From: Carrillo, Abiel X.
To: ["Michael Balaskovits"](#)
Cc: [Cherne, Curtis](#); [Biazar, Shahab](#); [Daggett, Kevin](#); [Romero, Ron](#); [MacKenzie, John](#)
Subject: One Central - K14D109
Date: Monday, December 05, 2016 4:30:00 PM

Based on information provided in your submittal dated 11-1-2016, the above-referenced Grading and Drainage plan cannot be approved for Foundation Permit. See comments below:

DRAINAGE MANAGEMENT PLAN

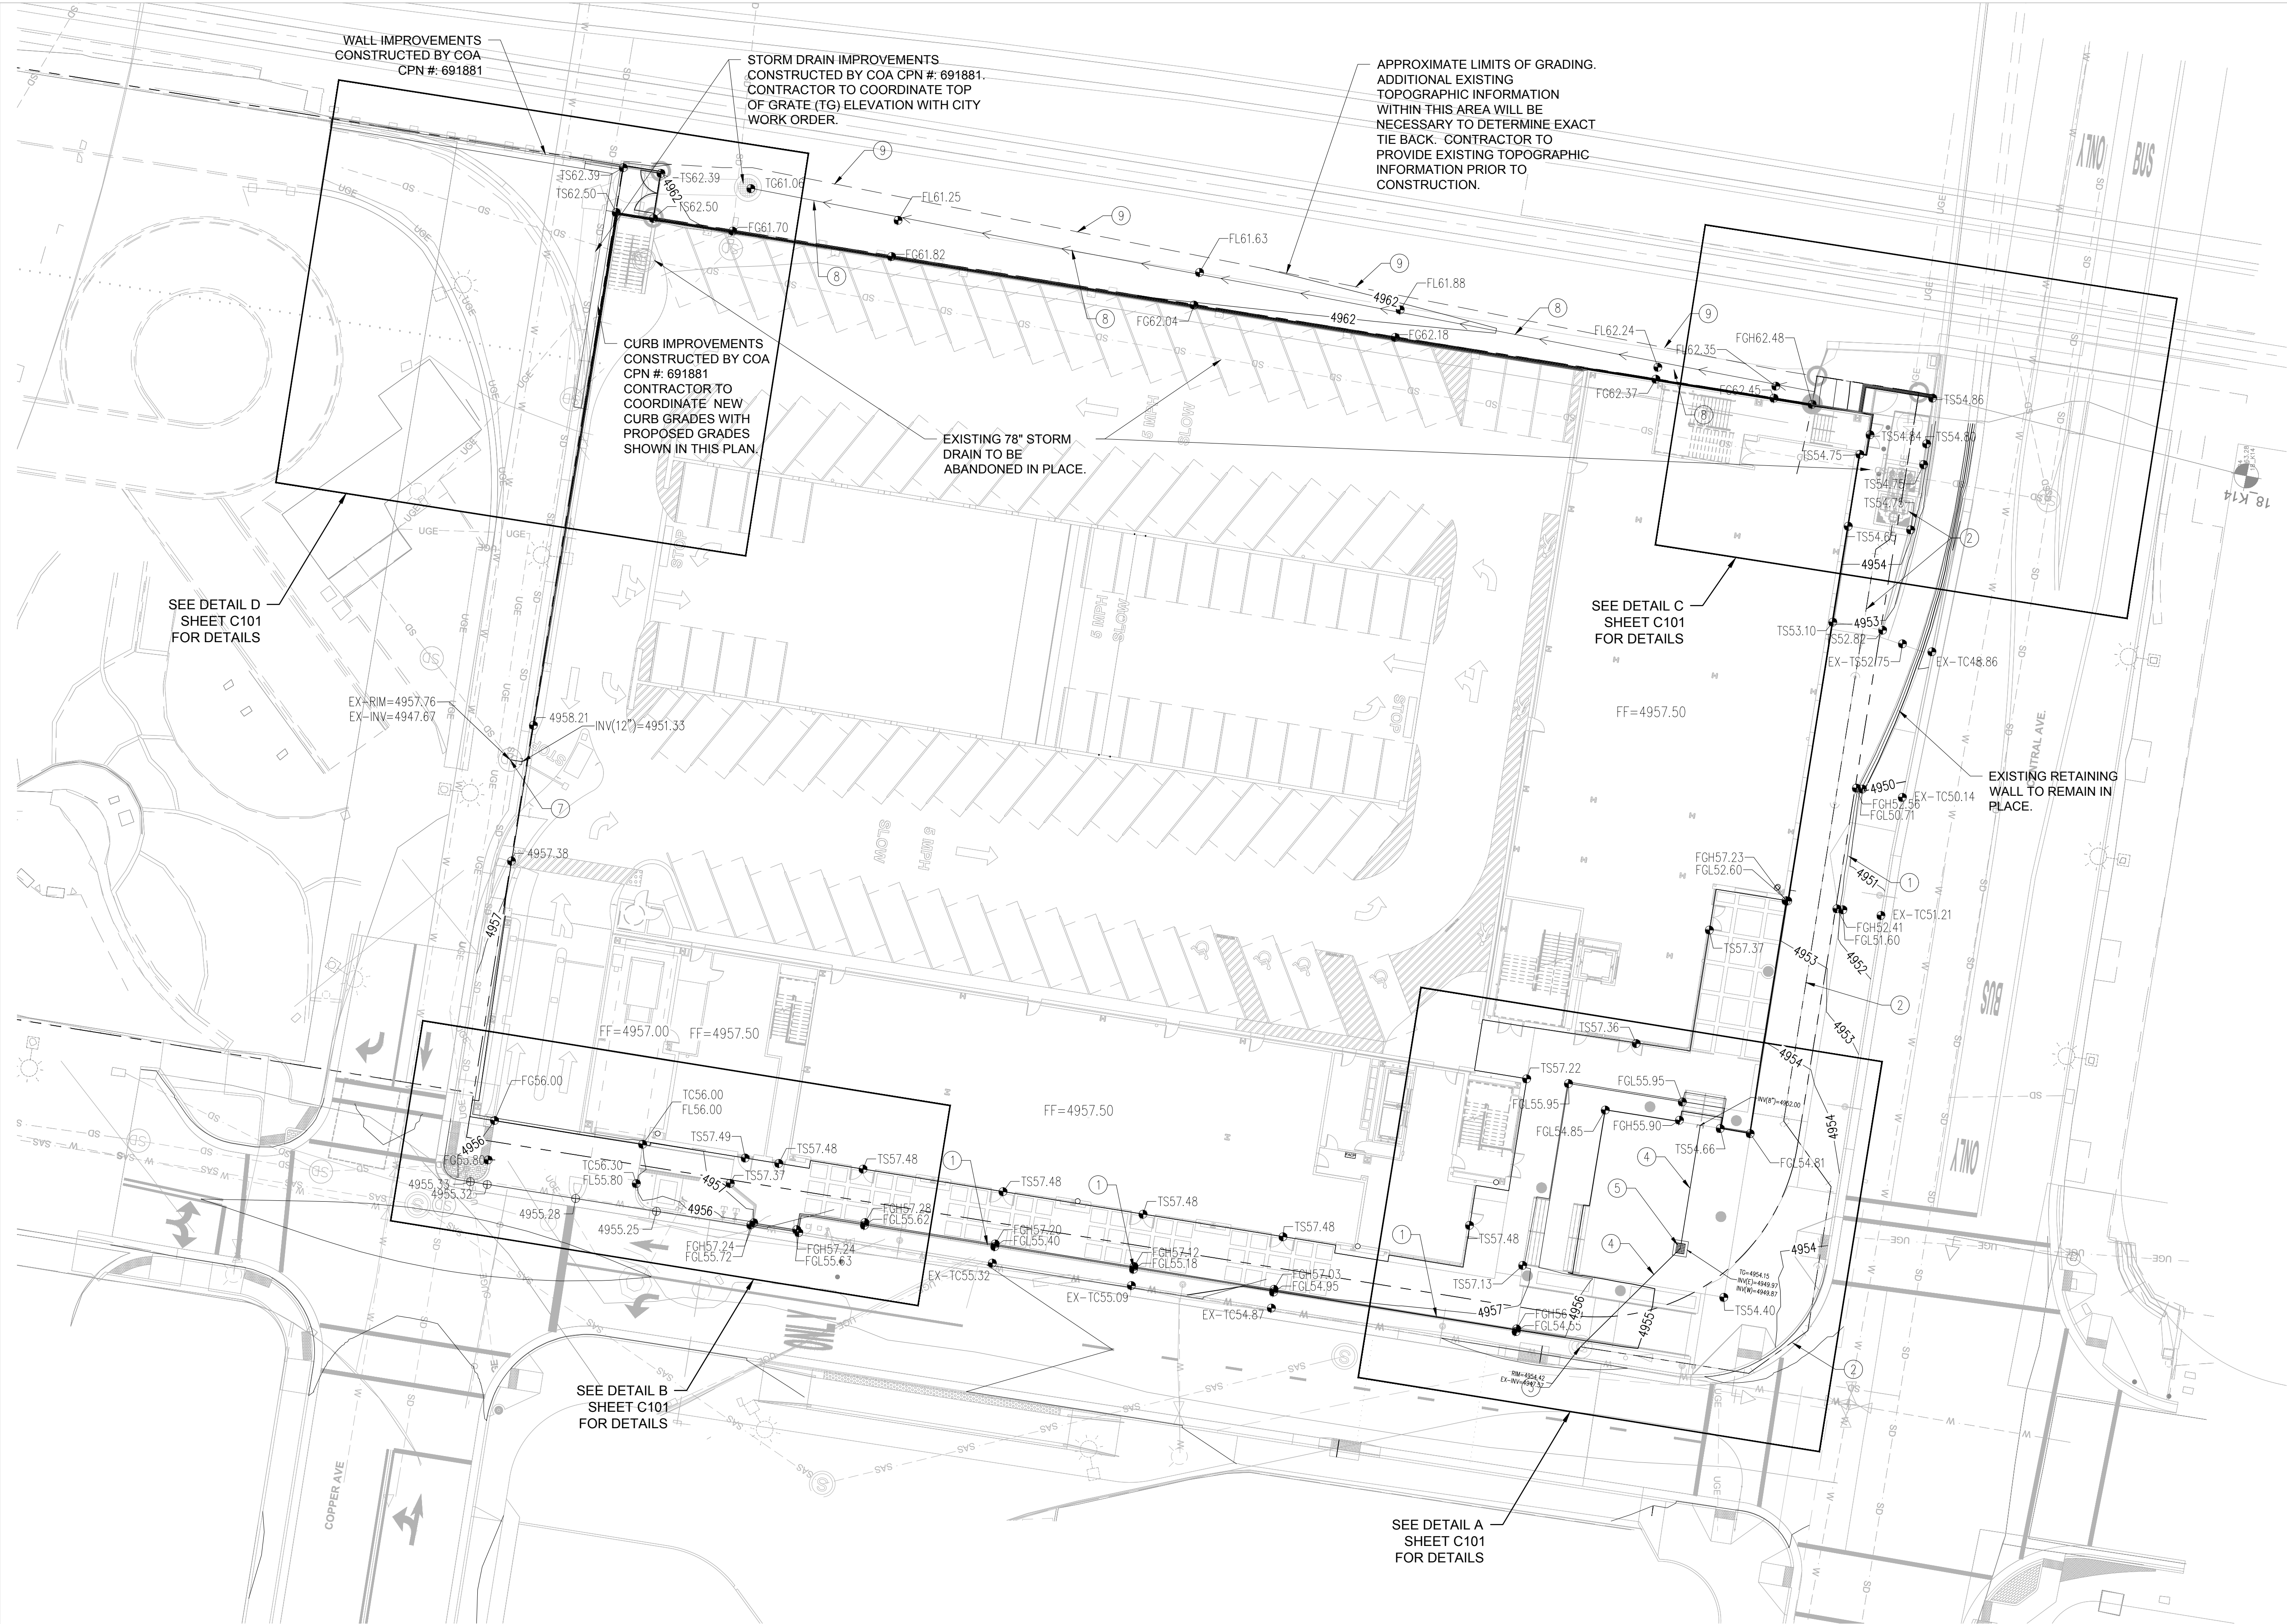
2. The plan needs to specify how the storm drains that will be placed under the building will be treated (capped, lean filled, etc).
3. We understand that a geotechnical study was to be completed to evaluate the previous item, has that been completed?

4. There is a storm drain shown as existing along the western wall of the future building. It is not clear that the line exists.
5. Per previous meetings, the area between the future building and the NMRX Right of way needs to be graded to drain to the north, where an inlet needs to be purposed to accept runoff from that strip (and from the Railroad right of way?). The work will likely require access permits from the NMDOT Rail Section.

6. DMD is planning some storm drain realignments under the future northeast corner of the building. Construction of the foundation would presumably need to occur after the realignments are complete.

7. The northern frontage of the parking lot structure will be within the trench prism of the 48" Storm Drain under Copper.
8. DMD will not allow the roof drains of the building to be directly connected to the Copper storm drain line.
